From: Hornby, Mark [Mark.Hornby@lancashire.gov.uk]
Sent: 22 March 2012 14:30
To: Graeme Thorpe
Cc: Ian McCarten
Subject: Consultation on planning applications 3/2012/0051, 0052, 0053 at 41 Dilworth Lane, Longridge

Application 3/2012/0052 Triple garage / office

Application 3/2012/0053 Three dwellings and associated parking area

Tre felling Plan Phase 1/2&3

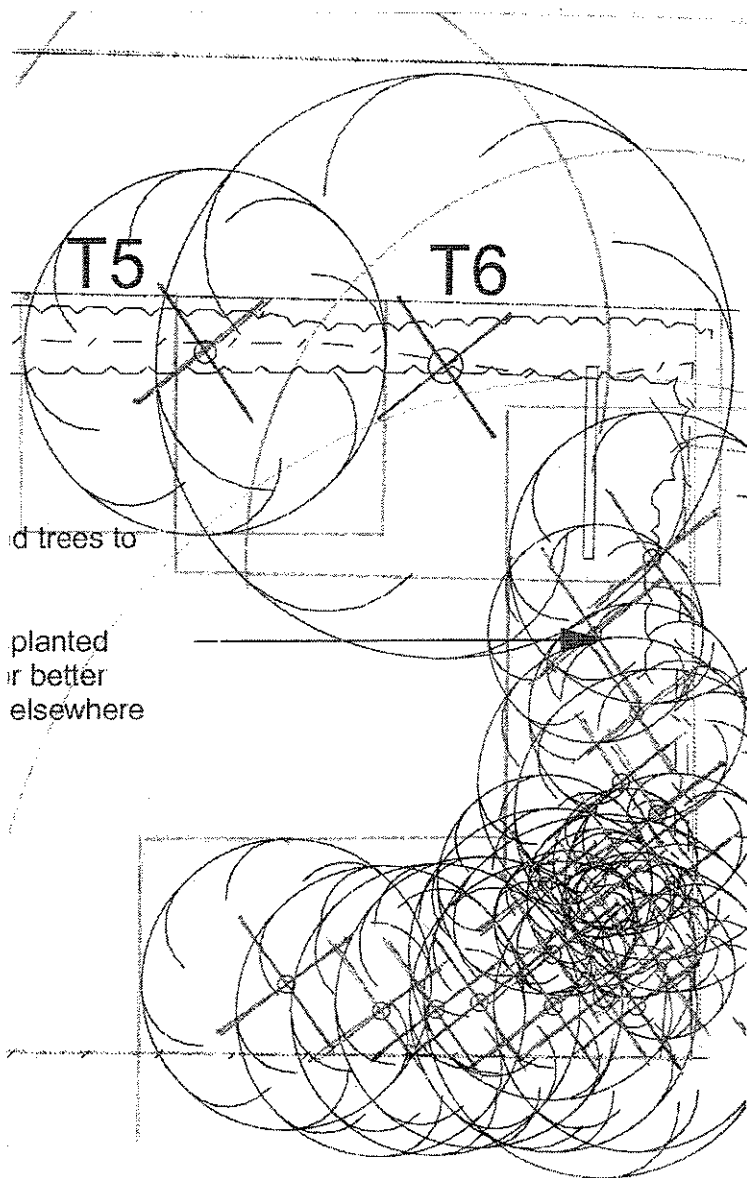
A visibility splay of 2.4m x 50m is achievable to the east with the removal of the first tree and to the west by lowering the frontage wall within the applicant's control to a maximum height of 1m, in conjunction with the relocation / realignment of the existing frontage fence and gateposts. This has been agreed in principle with the applicants agent as detailed on the attached plan and could be conditioned accordingly in any consent granted.

This is a resubmission of application 3/2011/0655. A satisfactory visibility splay of 2.4m x 50m at the proposed new access to the parking area can be achieved with the felling of a number of frontage trees and this has been agreed in principle with the applicants agent as detailed on the attached plan. The number of parking bays has been increased from 6 to 7 thus allowing two spaces per dwelling plus a visitor space. The parking area will need to be paved in suitable materials i.e. not loose gravel or similar and be available for use prior to occupation of the dwellings. The proposed dwellings have been moved back slightly from the edge of carriageway to allow a 1.5m footway and facilitate good visibility to the east. I would ask however that the railings to the front of the proposed dwellings be removed from the plans as they appear to encroach on the available footway width. Subject to these points being addressed satisfactorily I have no objection to the proposal.

It would be prudent to have revised site plan drawings submitted for applications 0052 and 0053 incorporating all the above points to clarify the access and parking arrangements for any consent granted.
